Appendix 19 Walking, Cycling & Horse-Riding Review: Review Report

Northampton Gateway
Roxhill

WALKING, CYCLING & HORSE RIDING
ASSESSMENT AND REVIEW (WCHAR)
REVIEW REPORT FOR PRELIMINARY
DESIGN STAGE

**A508 CHURCH LANE GRAFTON REGIS GENERAL ARRANGEMENT**

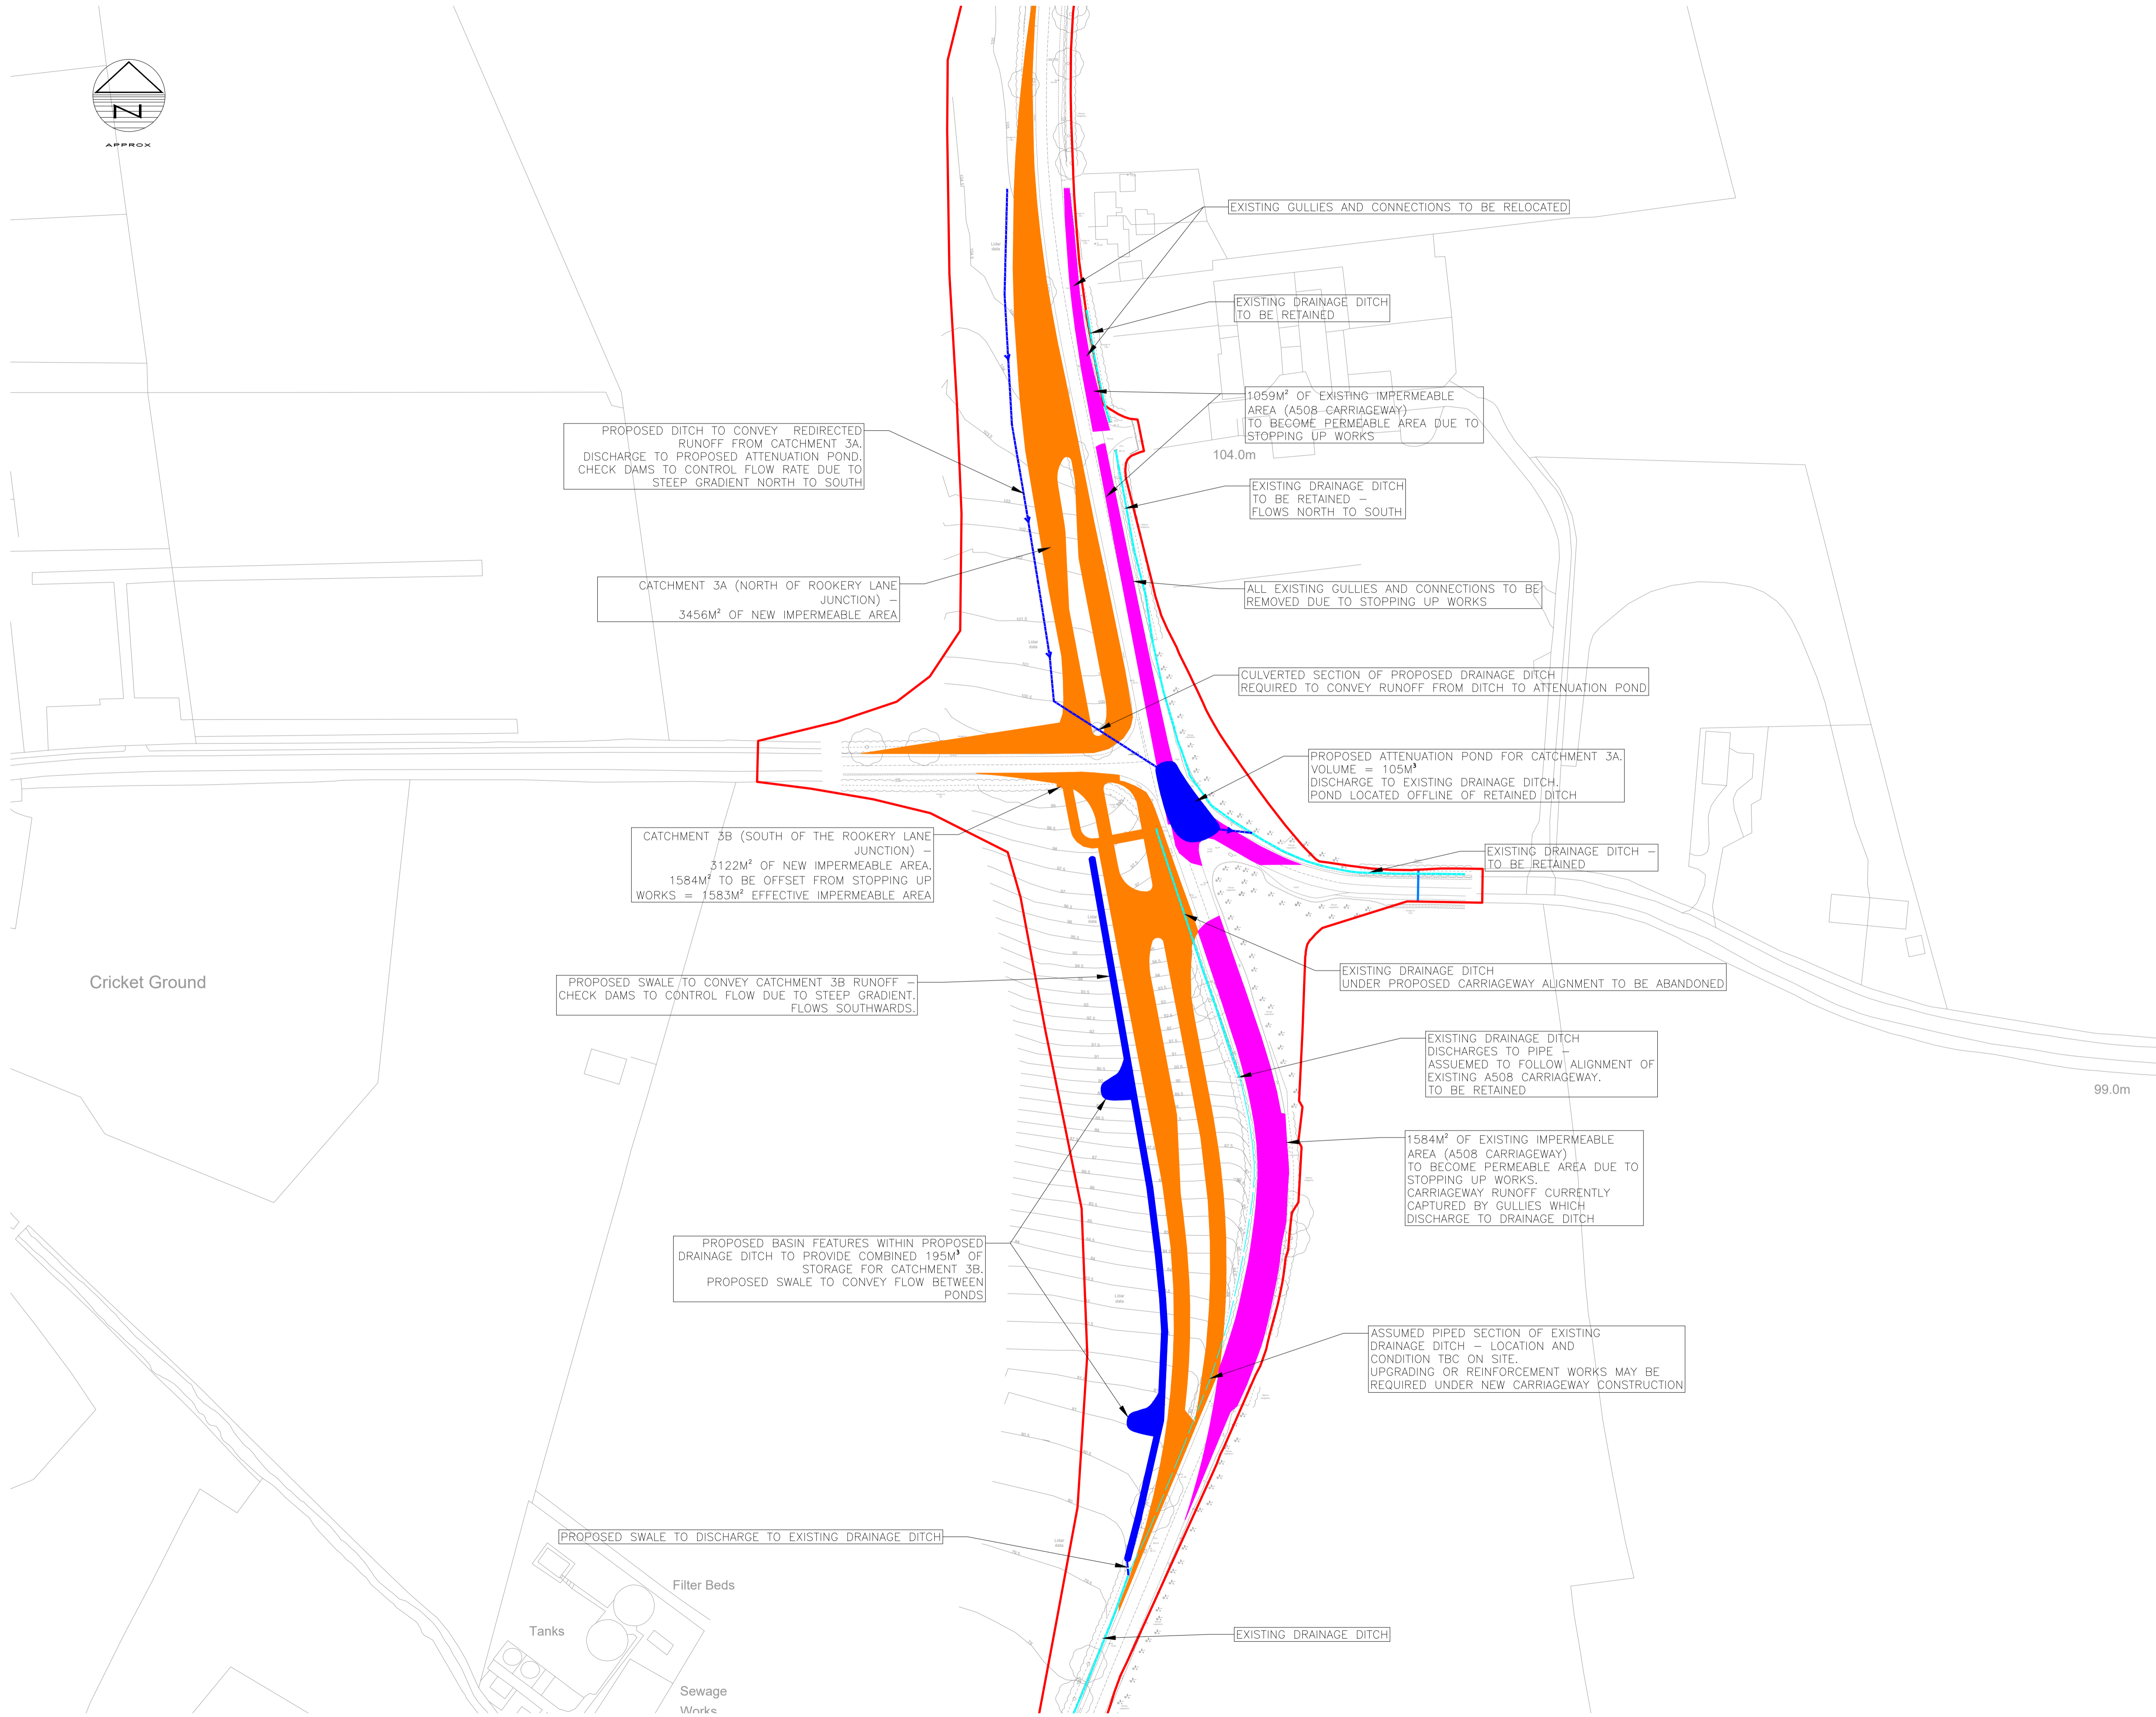
Opportunity		Realised?	Review against the preliminary design
22	Consider the need for a controlled crossing on the A508 to access the northbound bus stop.	In part	An uncontrolled pedestrian crossing has been provided via a central refuge, but no footway is shown linking that crossing to the bus stop. FINDING NGW_LR15

NGW_LR13	19	Reference to footpath KZ12 is omitted from the drawings.	Action: Add footpath KZ12.
NGW_LR14	21	It is unclear whether, and to what extent, footways at the Rookery Lane and Ashton Road junction are intended for use by pedestrians in conjunction with the central island.	Outcome: The east-west Rookery Lane to Ashton Road (and vice versa) route is intended for both pedestrians and cyclists. Action: Clarify the design to show the footways and cycleways around the junctions.
NGW_LR15	22	An uncontrolled crossing of the A508 via a central refuge is shown at Grafton Regis, but no linking footway is shown to the bus stop.	Outcome: A footway should be provided Action: Add a footway linking the central refuge to the bus stop.
